December 15, 2014

RE: SAD 228, Lot 7 Block 10 6509 Petirrojo Rd. NW Grading and Drainage Plan Engineers Stamp Date 12/8/14 (D10-D003P7)

Based upon the information provided in your submittal received 12/8/14, this plan is approved for Grading Permit and Building Permit.

GRADING AND DRAINAGE PLAN
LOT 7 , BLOCK 10 , UNIT 18 , VCS
ADDRESS: 6509 PETIRROJO RD, NW

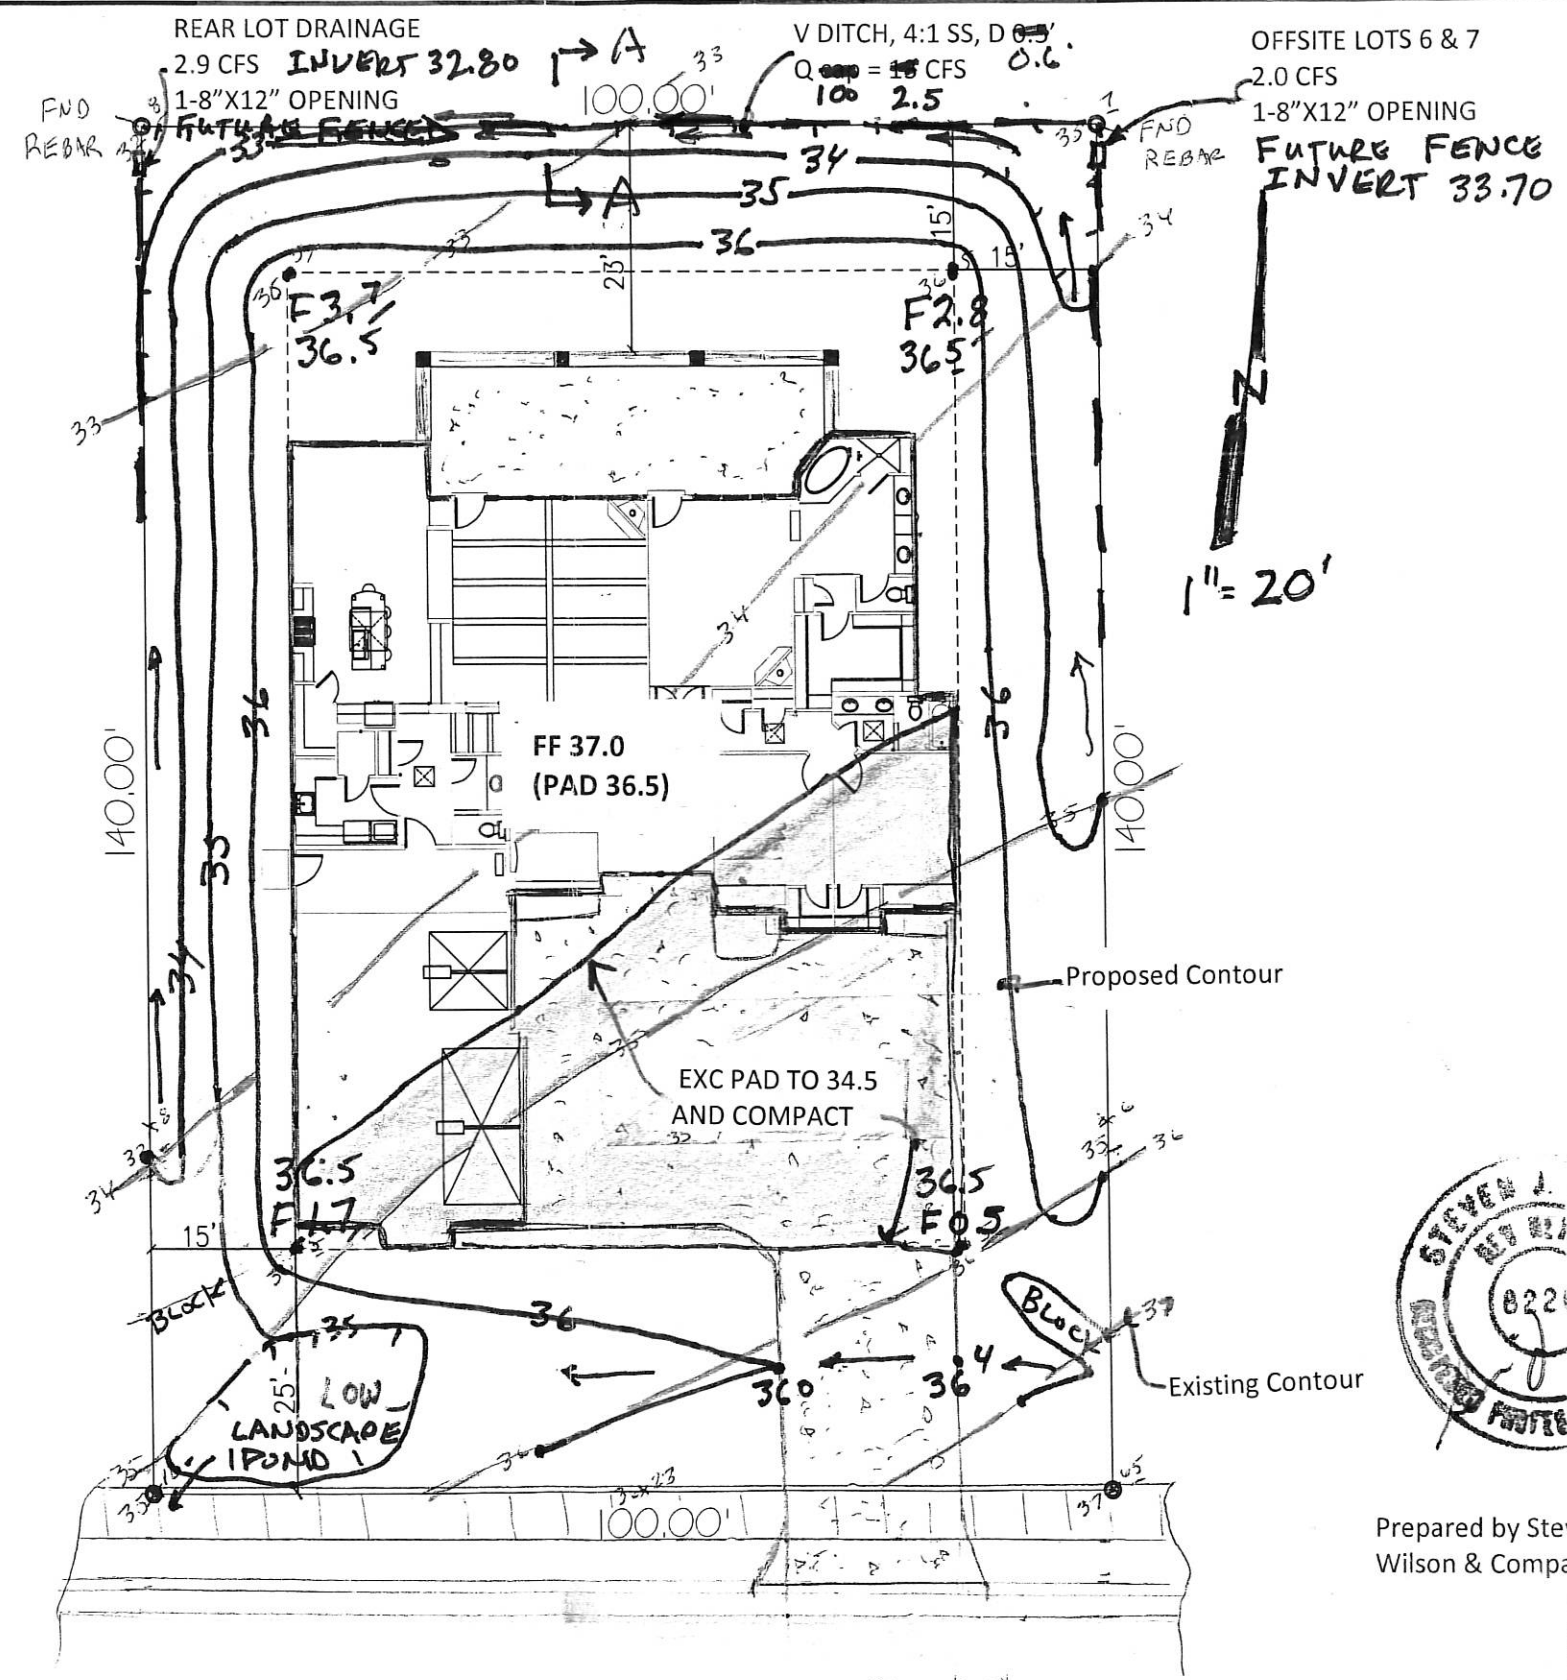
- Provide a Vicinity map, a FEMA map or designation, a narrative.
- Mention of the first flush per EPA standards is required. The amount required is .34" times the impervious area.
- Provide a section of the V Ditch and calculations for the ditch. 13.0cfs seems a bit too much. Is the ditch a shared ditch, if so where will the block fence be placed?
- What are the inverts of the openings? Is this a block fence? Future
- What is the flow line in the street?
